From: Thomas Callaway
Sent: 23 April 2015 14:26
To: Planning.Responses
Subject: RE: Planning Consultation on: Y/27/15/L and Y/26/15/PL

Engineers comments in respect to surface water drainage:

APPLICATION **Y/27/15/L**

Site Address: The Old Thatched Cottage North End Road Yapton BN18 0DL

Site Layout Plan

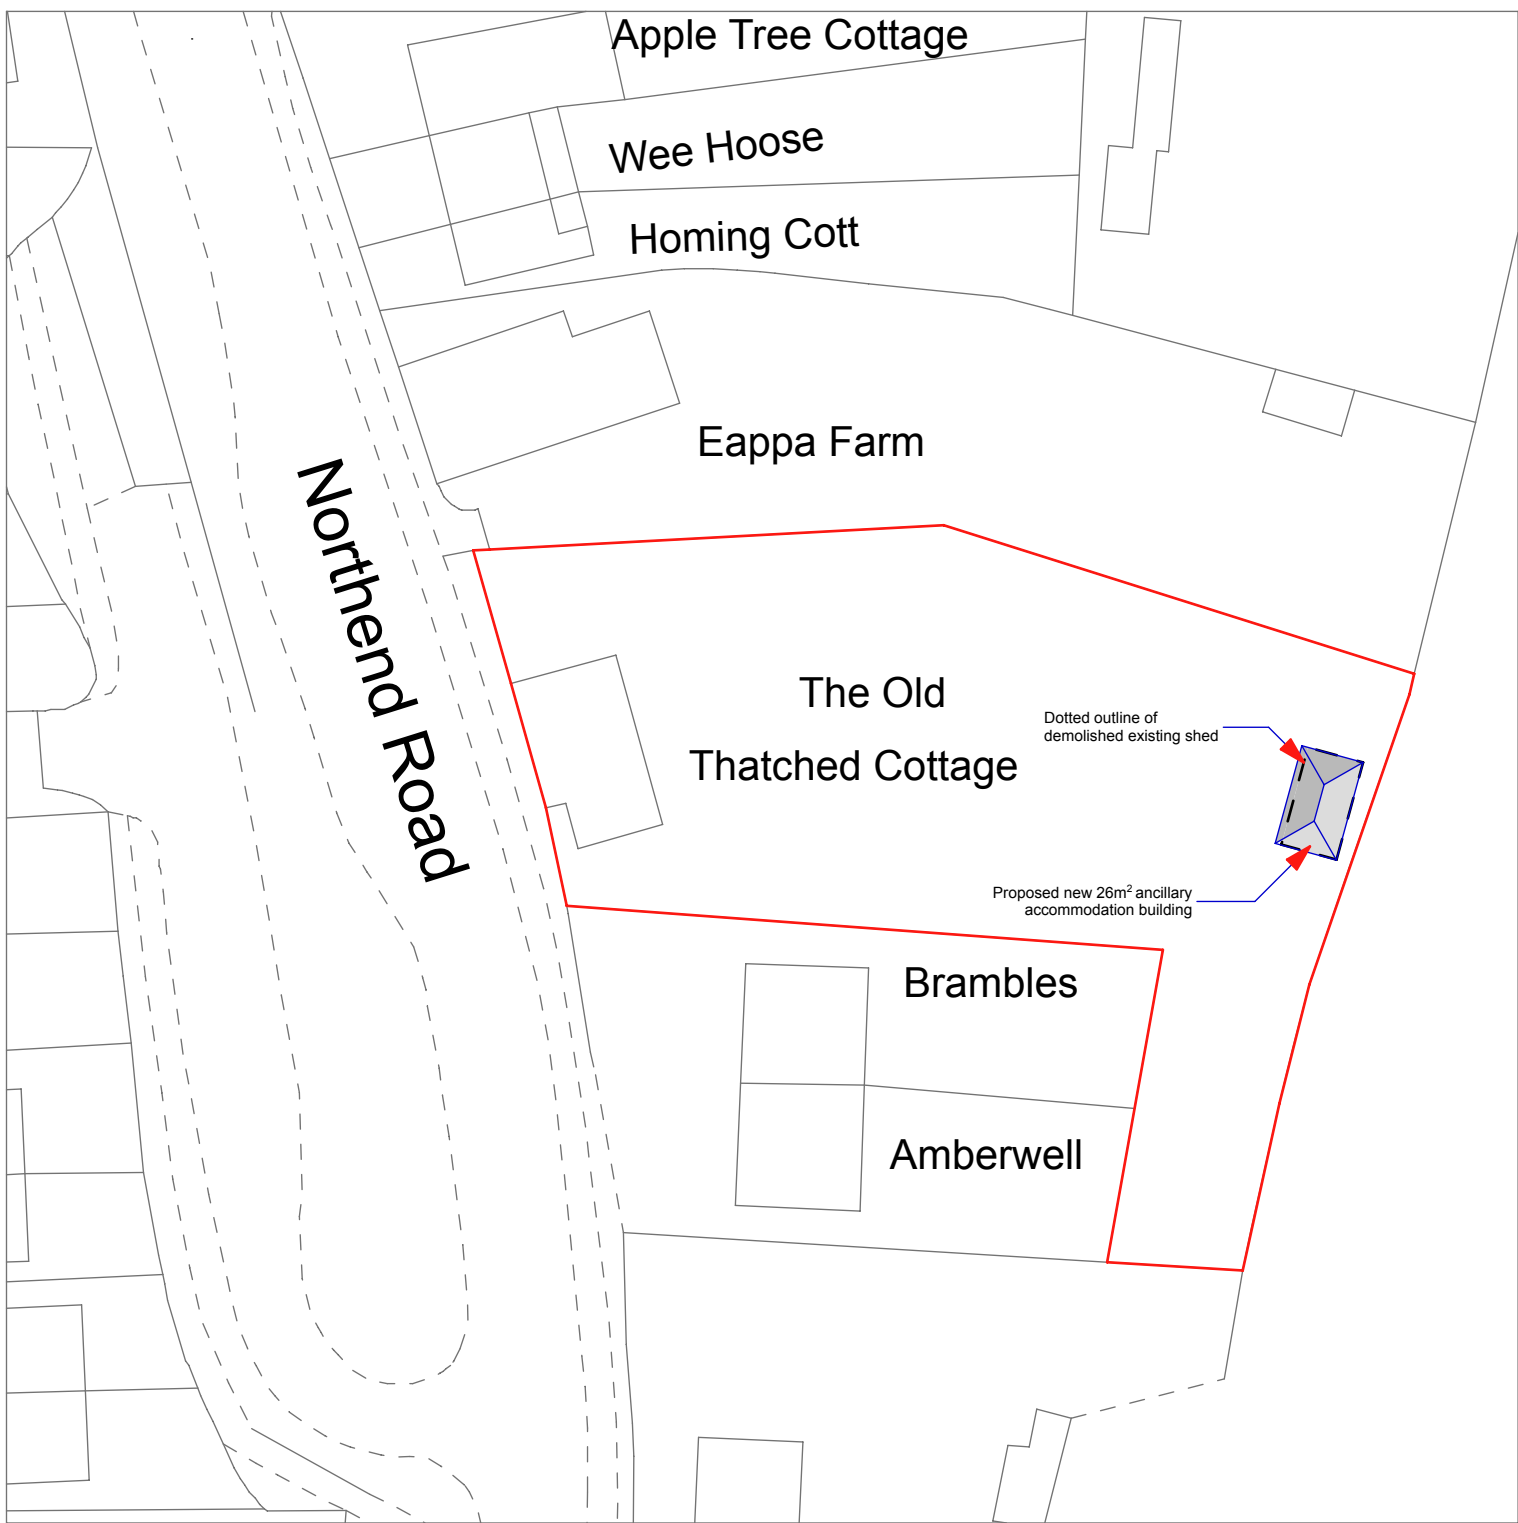
Surface water drainage is required for all new impermeable areas. Infiltration to be investigated.

Infiltration rates for soakage structures are to be based on percolation tests undertaken in the winter period and at the location and depth of the proposed structures. The percolation tests must be carried out in accordance with BRE 365, CIRIA R156 or a similar approved method and cater for the 1 in 10 year storm between the invert of the entry pipe to the soakaway, and the base of the structure. It must also have provision to ensure that there is capacity in the system to contain below ground level the 1 in 100 year event plus 30% on stored volumes, as an allowance for climate change. Adequate freeboard must be provided between the base of the soakaway structure and the highest recorded annual groundwater level identified in that location.

Any SuDS or soakaway design must include adequate groundwater monitoring data to determine the highest winter groundwater table in support of the design. The applicant is advised to discuss the extent of groundwater monitoring with the Council's Engineers. Supplementary guidance notes are also enclosed for information.

Please apply standard conditions ENGD2A.
